Application No: BE/149/20/PL
Site Address: 339 Chichester Road Bersted PO21 5AN
Description of works: Replacement of blockwork boundary wall with fence & new vehicular access. This site is in CIL Zone 4 (Zero Rated) as other development.

Thank you for your internet representation made on 17th January 2021 which has been recorded as an objection with the comments as follows:

SITE PLAN

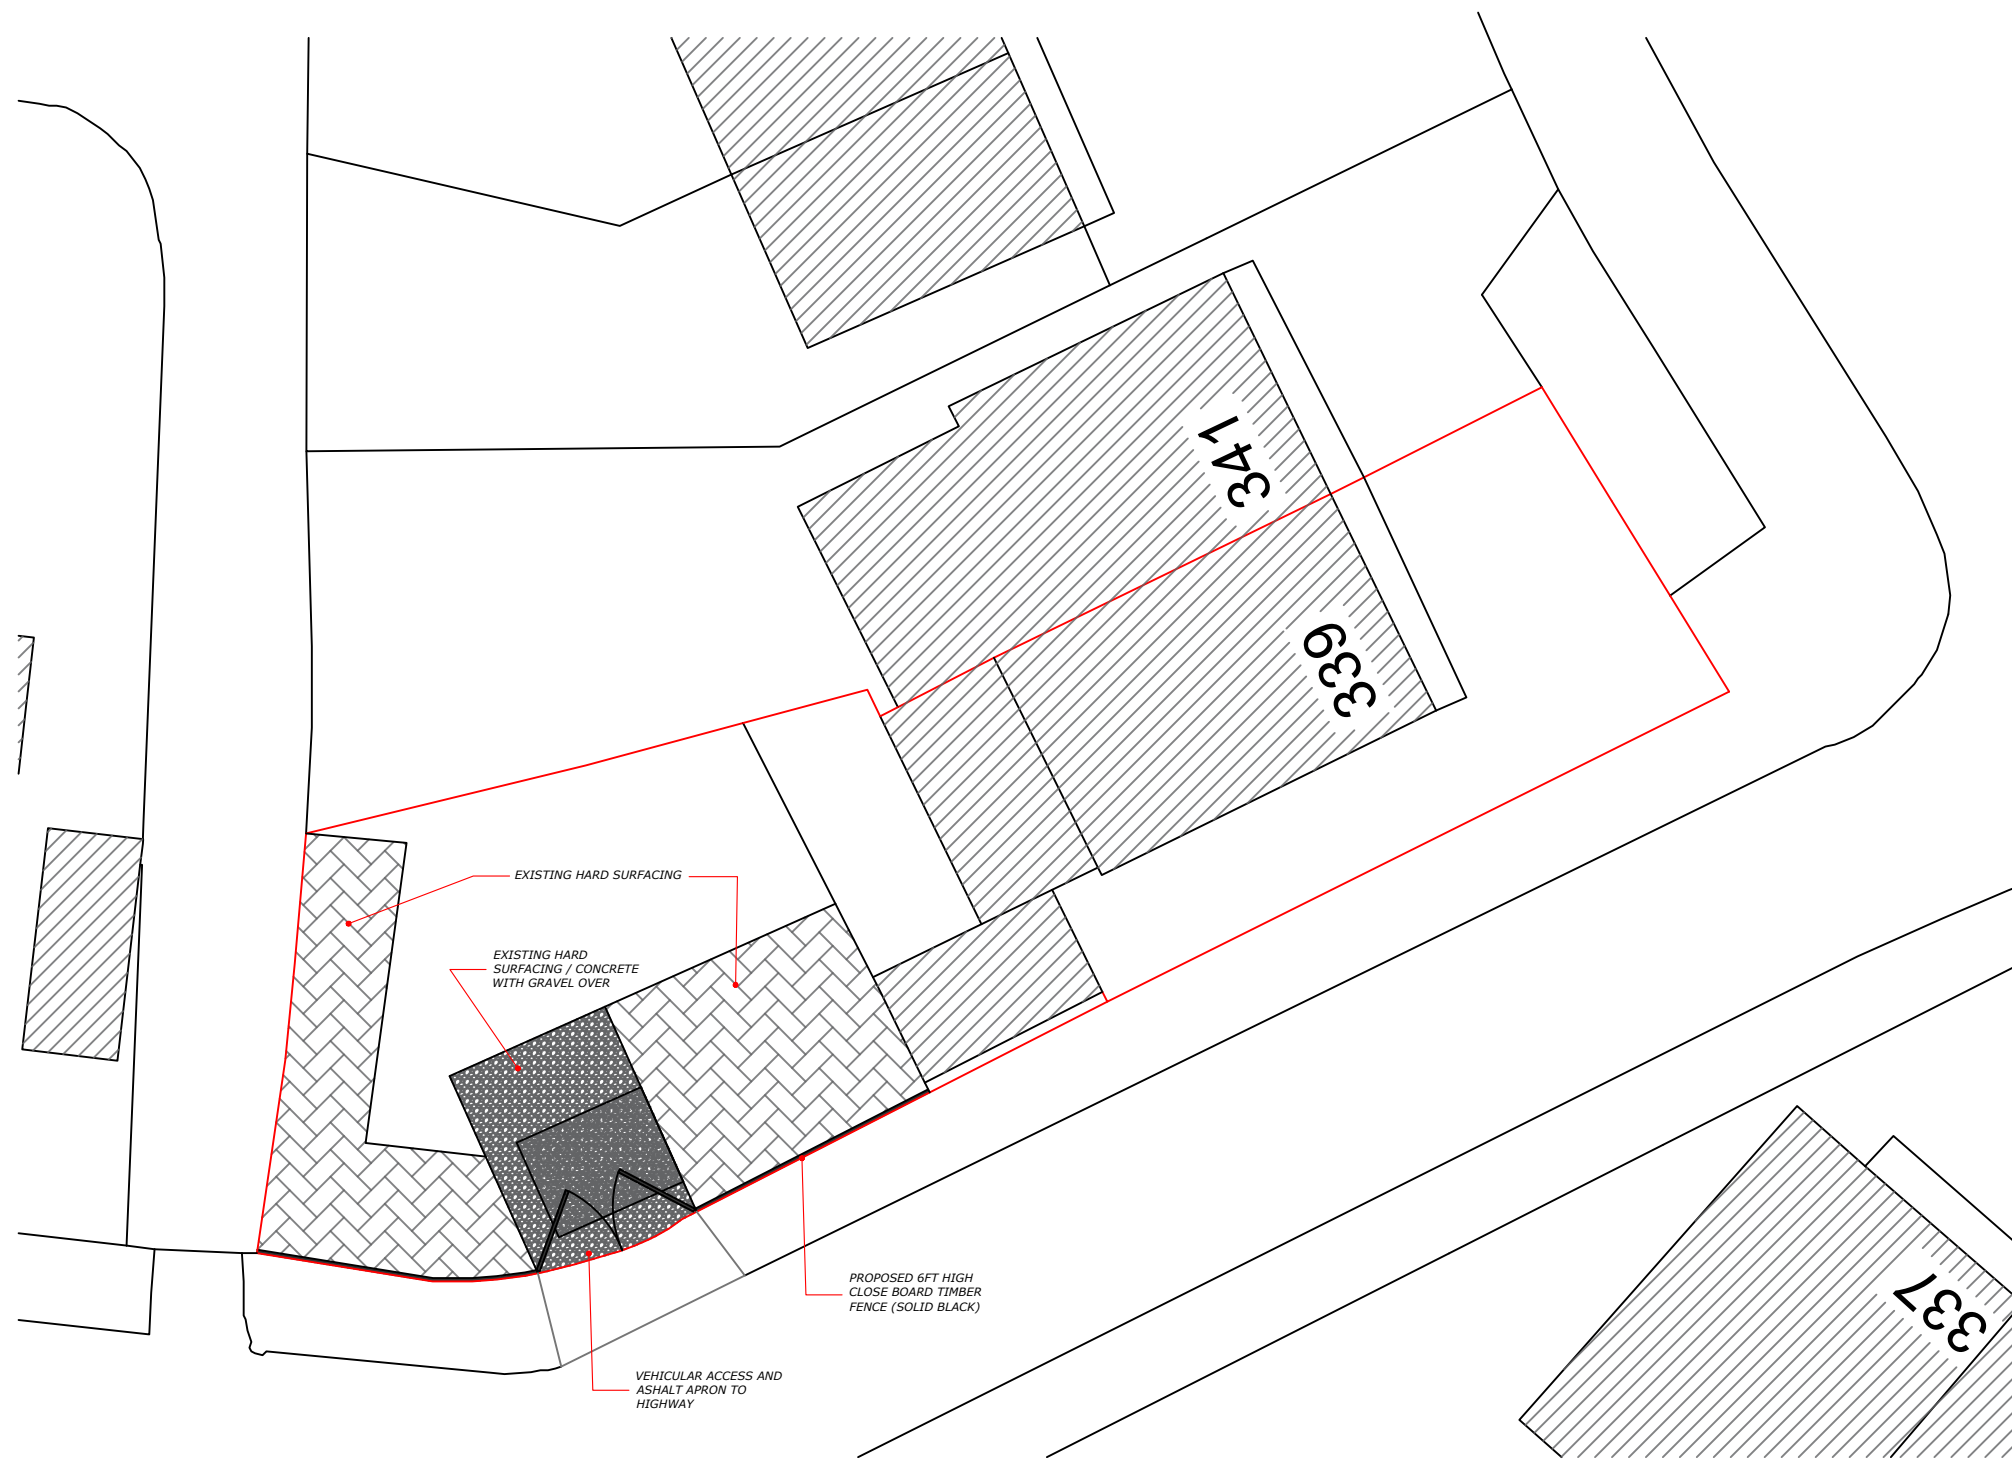
My second point is the fact that this work appears to have already been done with a drop kerb having been put in and the wall having been removed and replaced with a fence of the cheapest shuttering plywood. It makes a very disappointing entrance to our road and lowers the tone

Please can someone explain how this can be safe to have a drop kerb in this position and why has it been done in breach of the planning regulations. I am sure this is a commercial venture being undertaken and most certainly not in keeping in a residential area.
